Recommendation Report for Planning Permission for Works or Extension to a Dwelling

REF NO: FG/193/21/HH

LOCATION: 5 Colindale Road
Ferring
BN12 5JF

PROPOSAL: Two storey side extension & ground floor front extension.

Drg No.
DENRA/1916/2

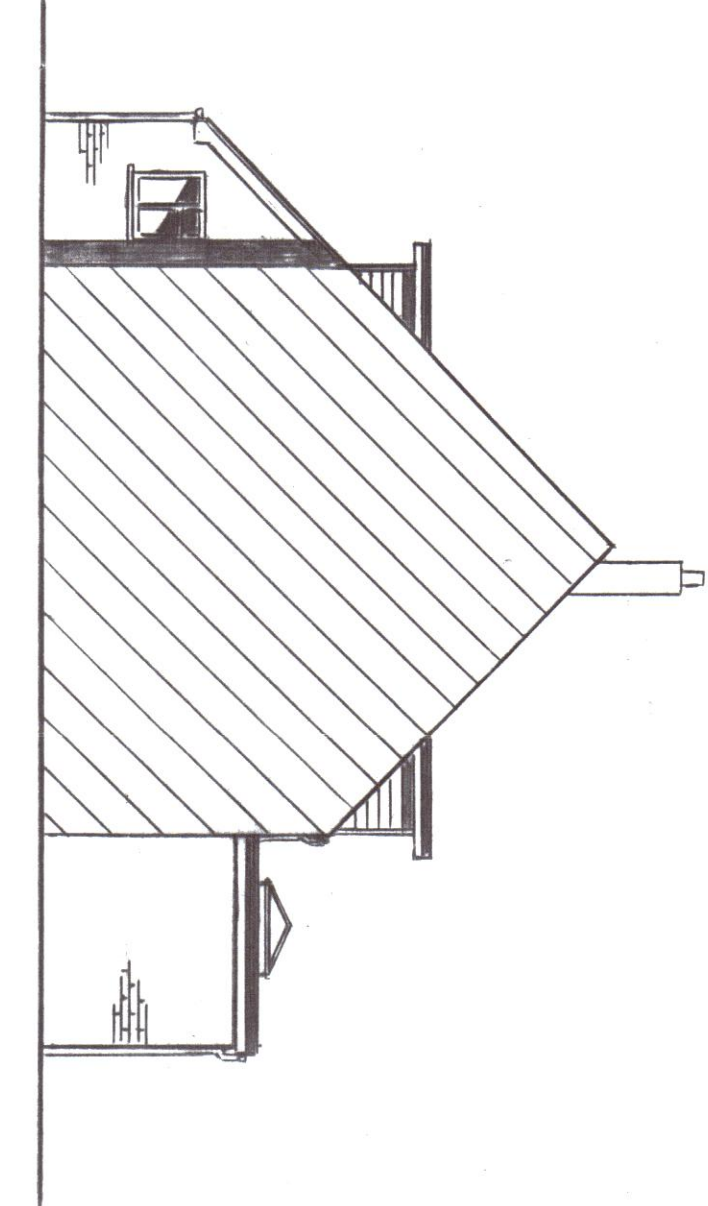
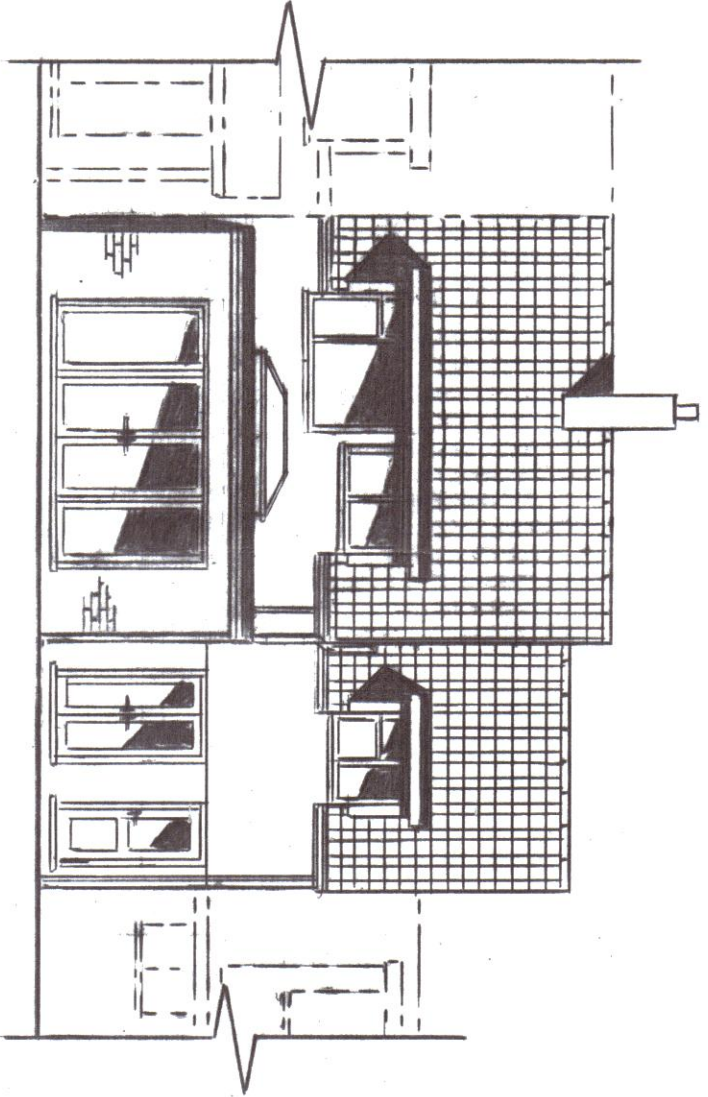
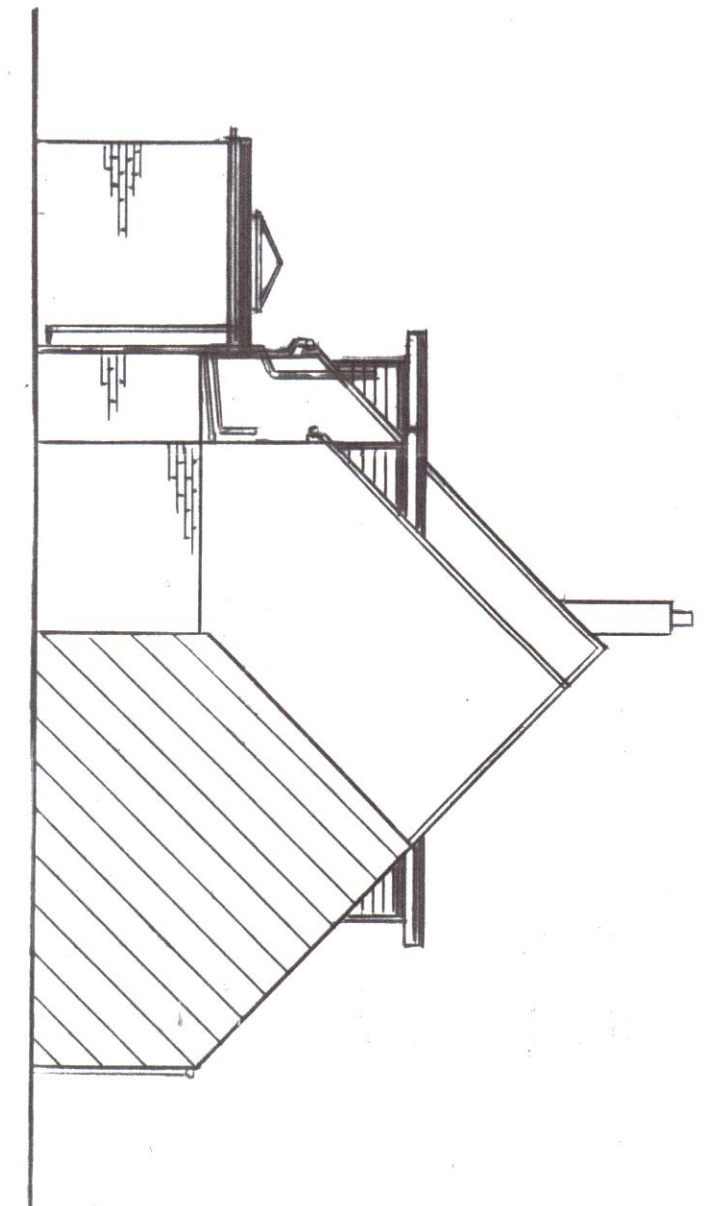
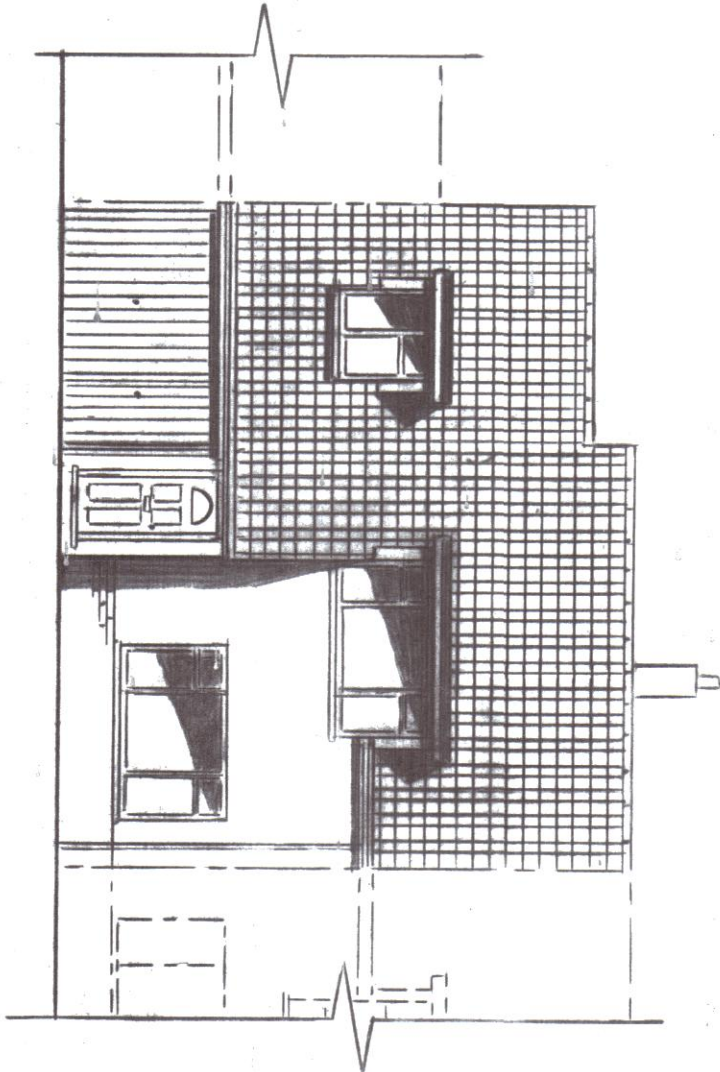
The proposed two storey side extension increases the height of the existing ground floor garage roof from approx. 4.9m to a height of approx. 7m. The peak of this proposed roof height increase is lower than that of the existing peak of the host dwelling. Furthermore, the proposed rear roof slope also matches the existing pitch of the host dwelling. The proposed side extension also projects approx. 2.5m to the rear of the existing garage. The scale of the proposed side extension is modest. The host dwelling has an existing ground floor single storey garage with a tall pitched roof. This side extension is sympathetic, visually integrated and subservient to the host dwelling in terms of form, scale and sitting. The proposed side extension does not cause significant adverse harm to street scene or surrounding character of area so complies with policy D DM1 and D DM4 of the Arun Local Plan.

The proposed second storey extension above the existing garage continues the pitched roof design at the same angle and integrates a small front and rear dormer. Both dormers are approx. 1.5m in height, approx. 1.4m in depth and approx. 1.7m in width, making them small, subservient additions. The rear dormer is not visible in the street scene however, the front dormer is. The front dormer, as noted, is a small and subservient addition with matching materials. Furthermore, the locality has many examples of similar front dormers and so the front dormer is considered appropriate, visually integrated and subservient with minimal impacts on the street scene. This is in accordance with policy D DM4(a),(b) and (e).

The proposed front extension is an infill of the existing front roof canopy alongside the existing garage. The proposed front extension is approx. 2m in depth and approx. 1.2m in width, bringing the front door in-line with the existing front elevation. Despite being on the front elevation, the proposed front extension is of a small scale. It is considered well integrated, subservient and an appropriate addition to the dwelling with no significant adverse impacts to the character of the host dwelling, the street scene or the locality.

dwelling and this complies in terms of size and scale. It states side extensions should also in most cases be set down from the existing roof ridge height by a minimum of 0.5m, and should have a building frontage no greater than 70% of the existing building. It states that two storey extensions can minimise their impact on street scene by incorporating the same angle of pitch as the existing roof so the proposal complies.

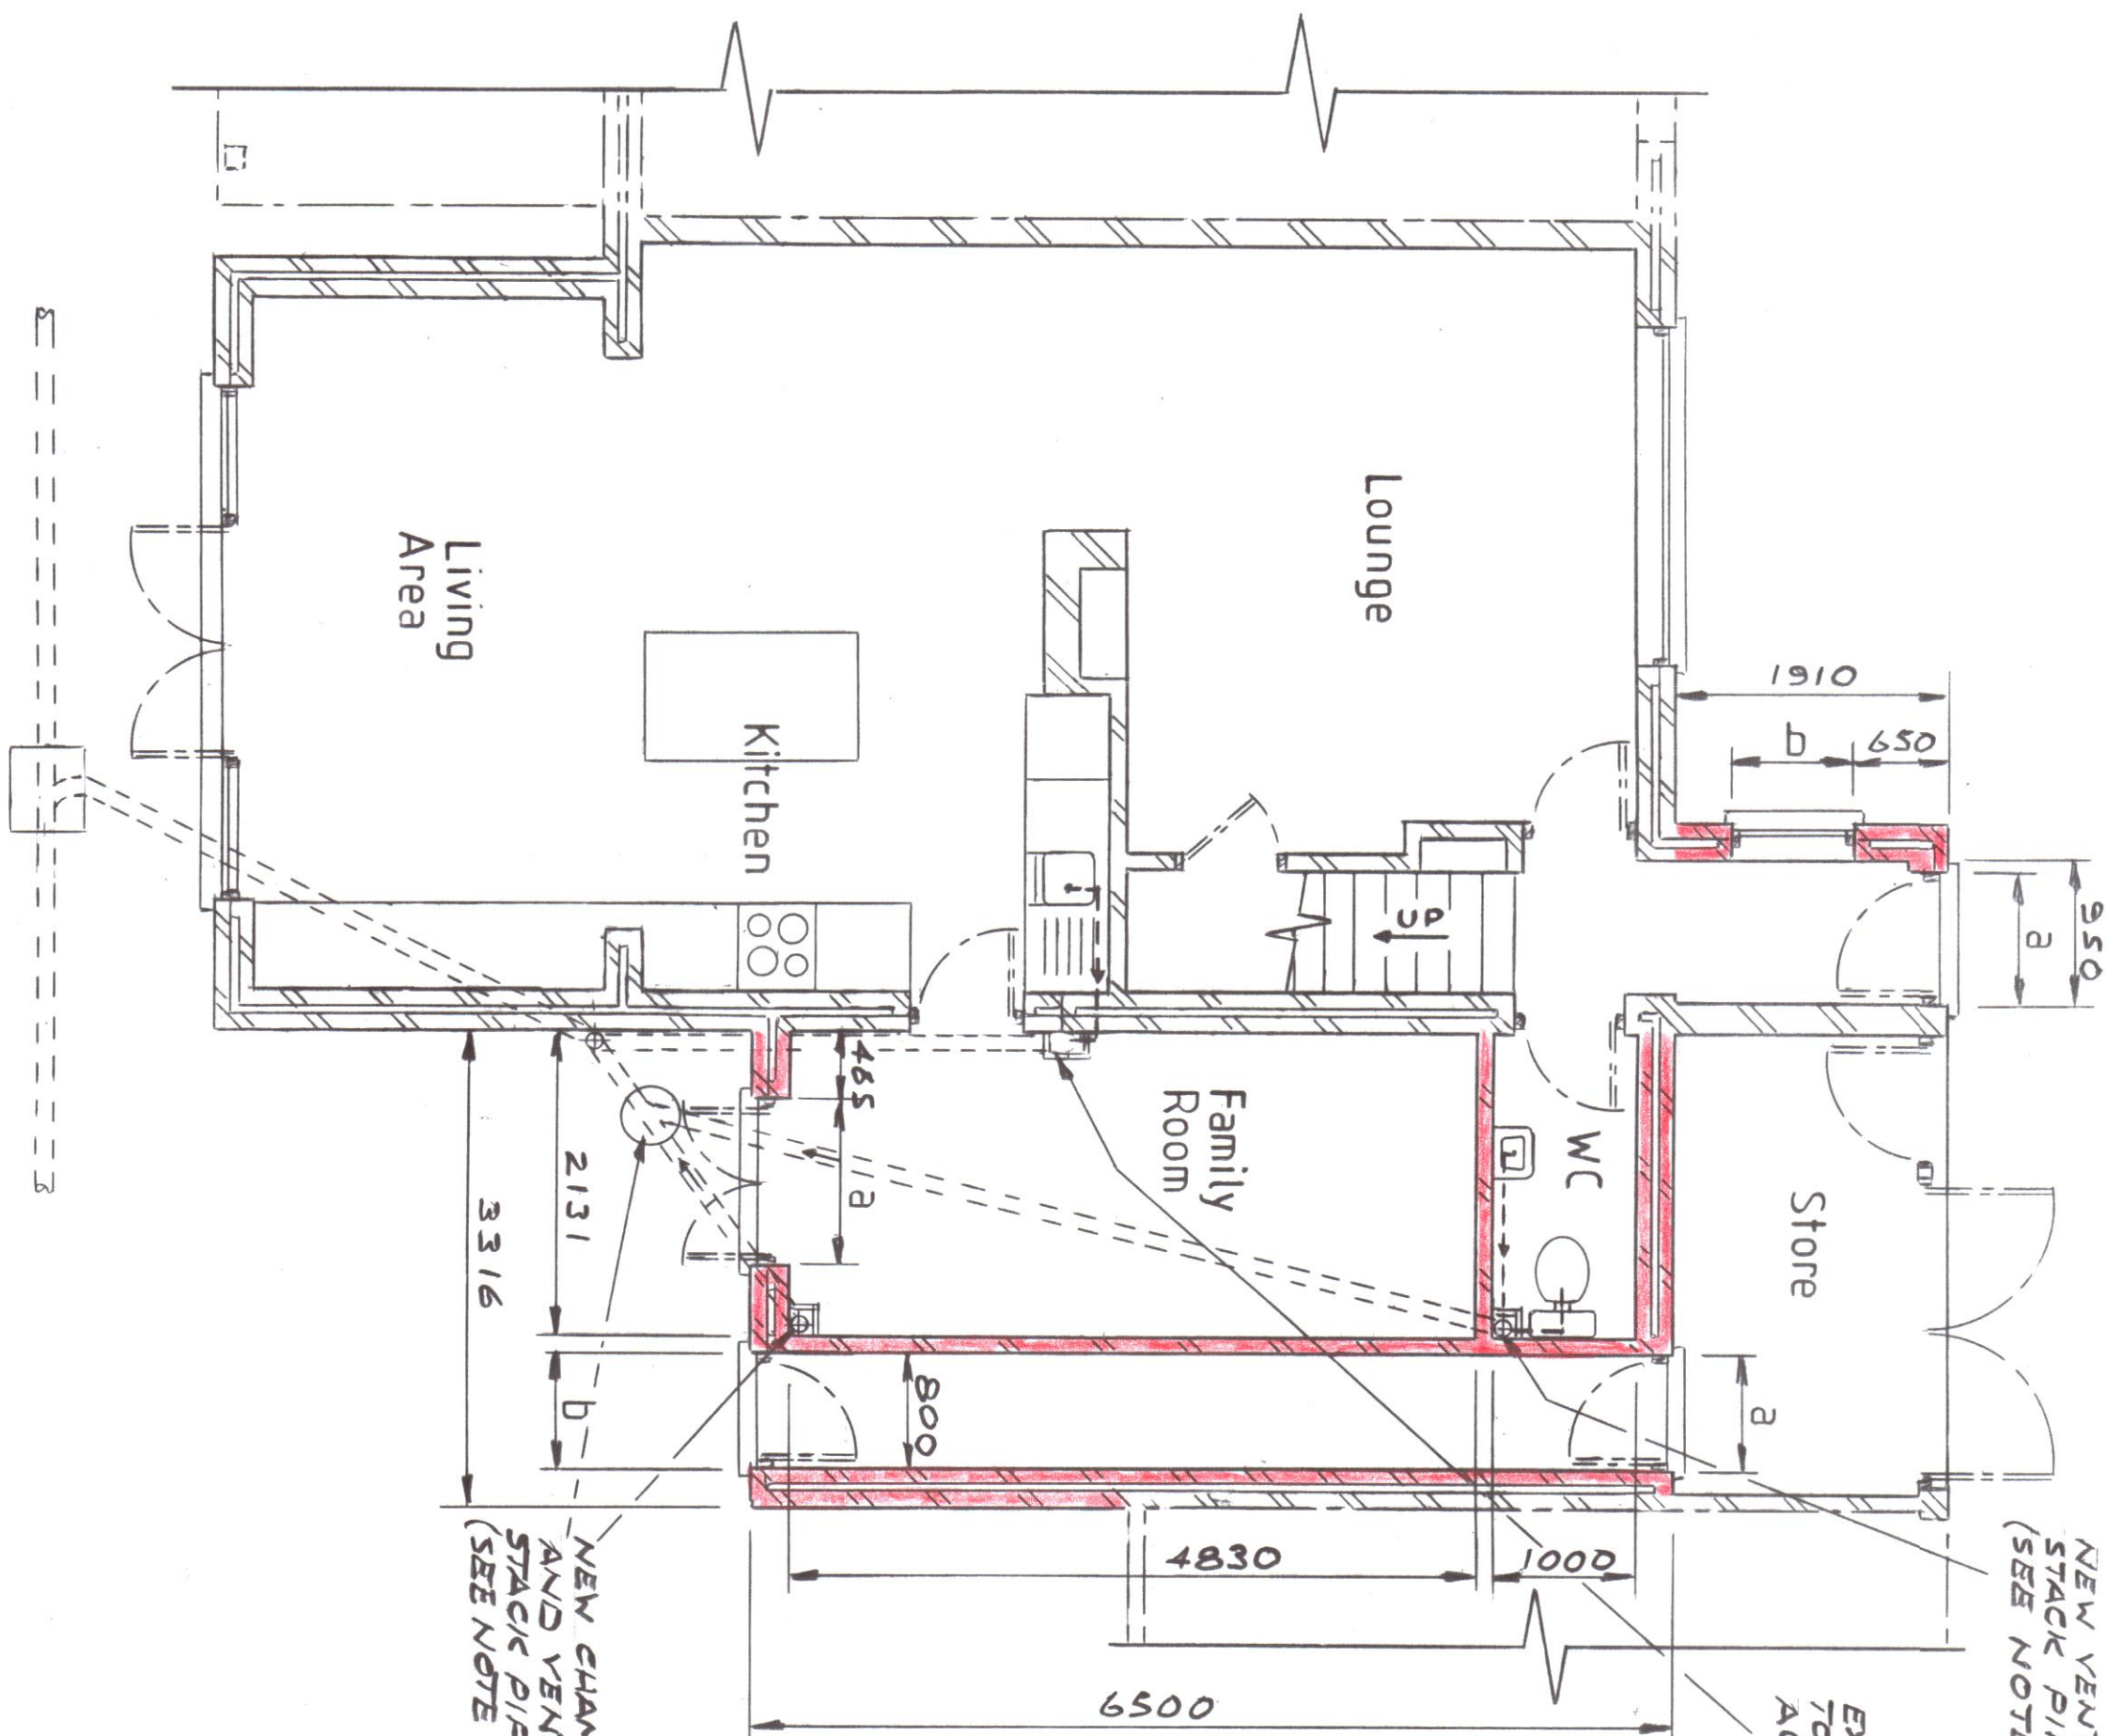
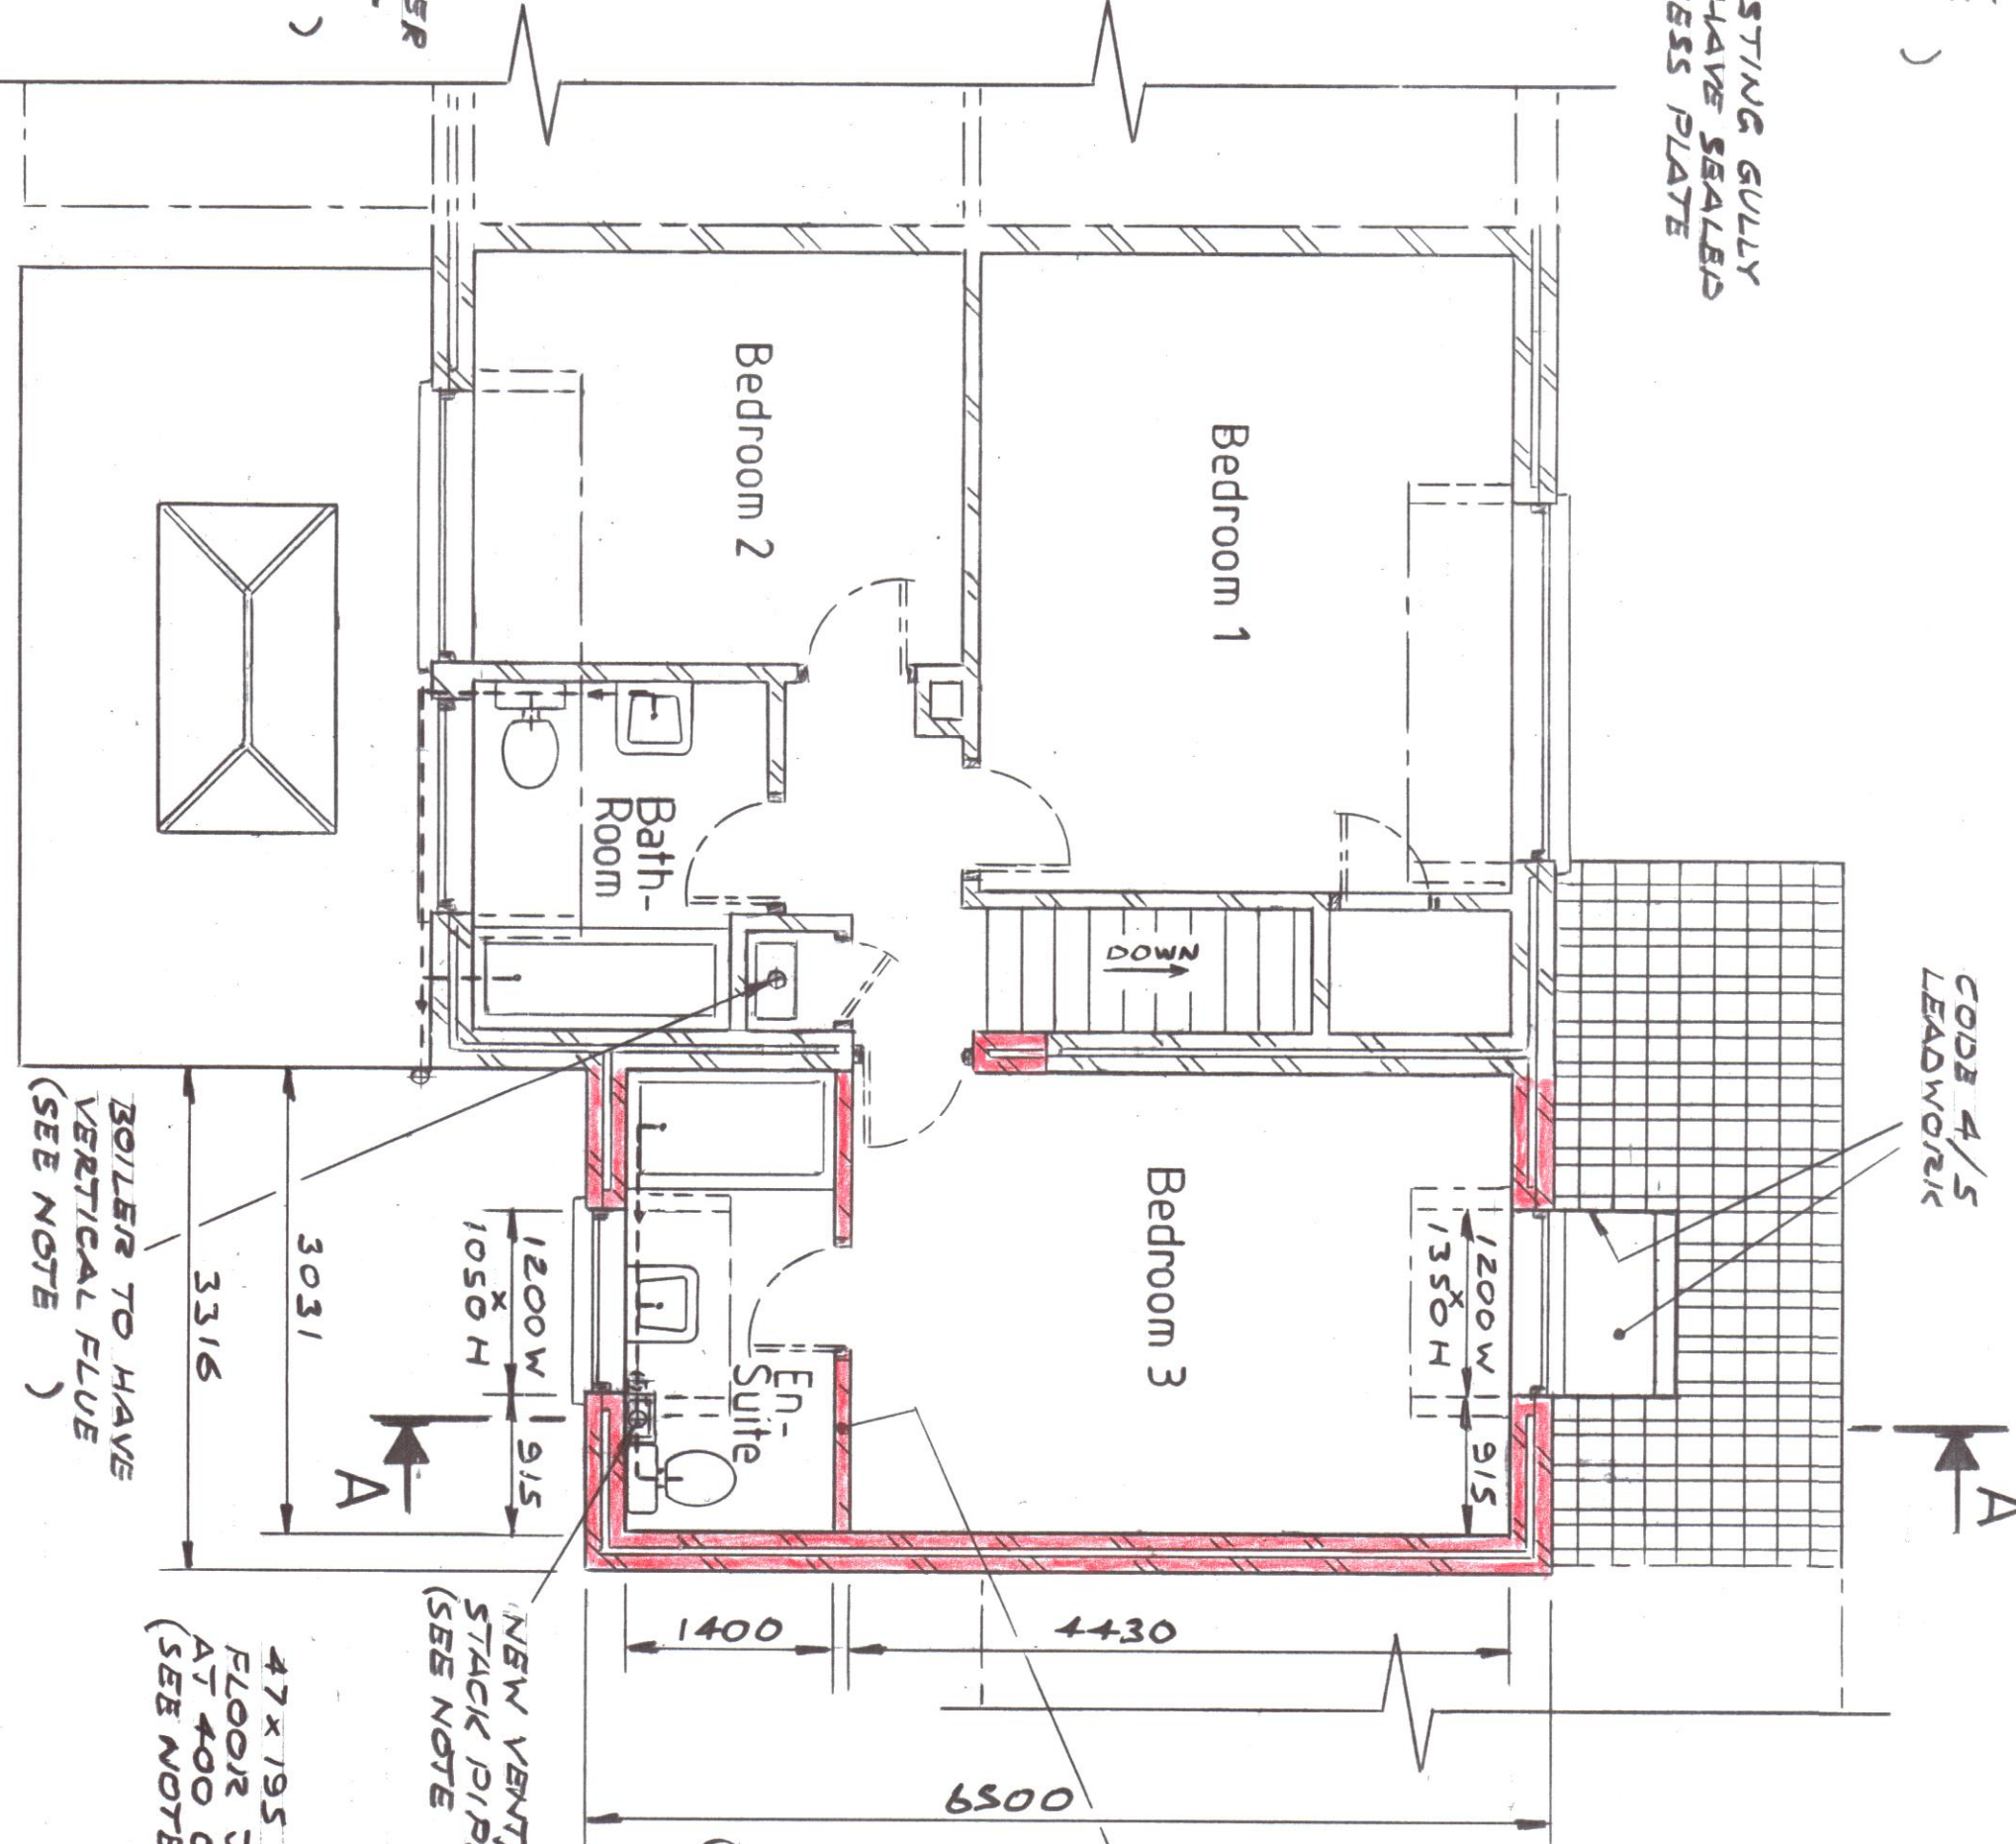
The property is a terraced, two storey dwelling, with a ground floor garage attached. The proposal seeks a two storey extension on the southern side of the host dwelling over and behind the existing garage. This would allow for the conversion of the garage into a 'family room' and the above second storey would house a third bedroom and associated en-suite.
